9th December, 2010

Re: Development Application MP10_0160 (Scottish Hospital, 2 Cooper St, Paddington)

STEPHEN STREET ELEVATION

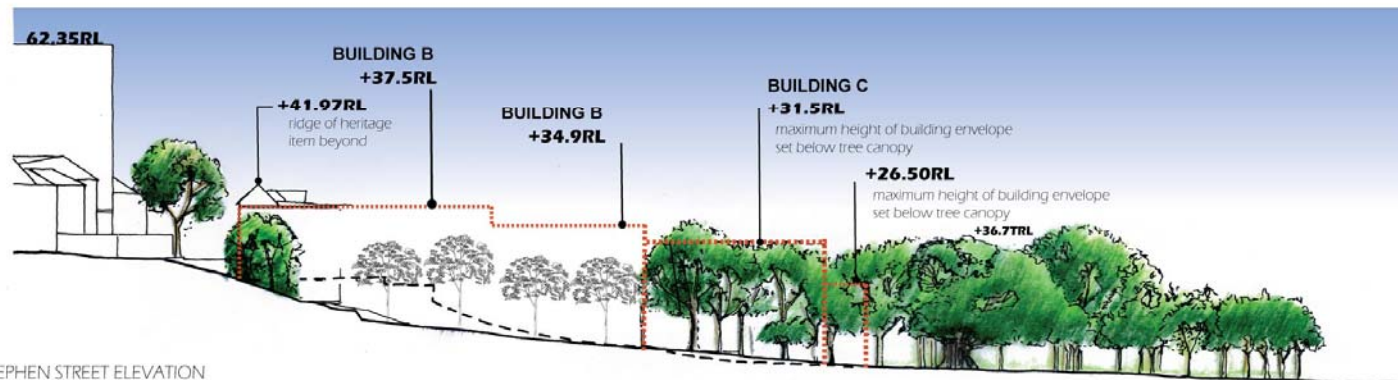
- The development is far too large and will destroy much on the greenery enjoyed by residents in the area.
- The development is too close to Stephen St and will be very intrusive for residents living at the Cooper St end of Stephen St. There should be greater setbacks between the aged care facility and Stephen St allowing residents adequate space.

- The new trees to be planted on Stephen St are inadequate and will fail to grow to significant size for many years (if ever). There appears to be inadequate space for the trees to grow and the same species of tree have failed to grow well in the Dillon St Reserve. I believe the development drawings are very misleading and that even after 10 years of growth the trees will be approximately 50-80% smaller than the drawings and models in the development proposal suggest.
